Application Ref:	2026/0033			 Ribble Valley Borough Council www.ribblevalley.gov.uk
Date Inspected:	23/04/2026	Site Notice:	23/04/2026	
Officer:	EP			
DELEGATED ITEM FILE REPORT:				APPROVAL

Development Description:	Regularisation of change of use of part of car park for siting of hot food takeaway cabin (use class sui generis).
Site Address/Location:	Wellsprings Hotel, Clitheroe Road, Sabden BB7 9HN

Scale:	Proposed site layout
1:200

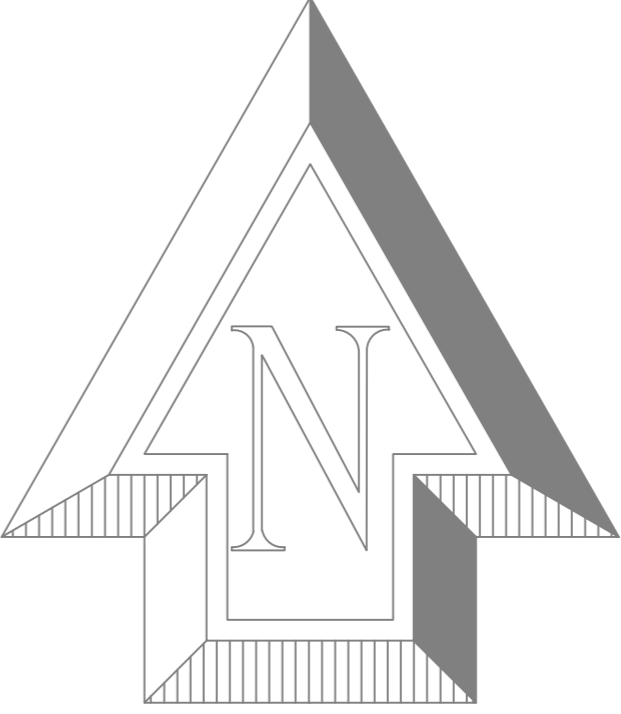
The development is a small timber constructed cabin building located immediately adjacent to the existing highway within the car park for Wellsprings restaurant. There is also a small seating area adjacent to the cabin which has been positioned on an existing elevated platform. In respect to scale, the building is modest in footprint and does not appear overly dominant within the site or surrounding landscape.

The timber construction, incorporating natural materials, is appropriate in this national landscape setting and integrates into the surrounding landscape to a degree. As it stands, the colouring of the timber is quite orange and on first visit this appeared quite stark in contrast with the surroundings. Discussions were had with the applicant in respect to staining the cabin in a more neutral brown shade. However, since first submission of this application, the timber has already begun to weather and is less visually prominent within the landscape. It is therefore not considered reasonable to refuse the application on this basis, the structure will continue to weather and become more inconspicuous within the landscape.
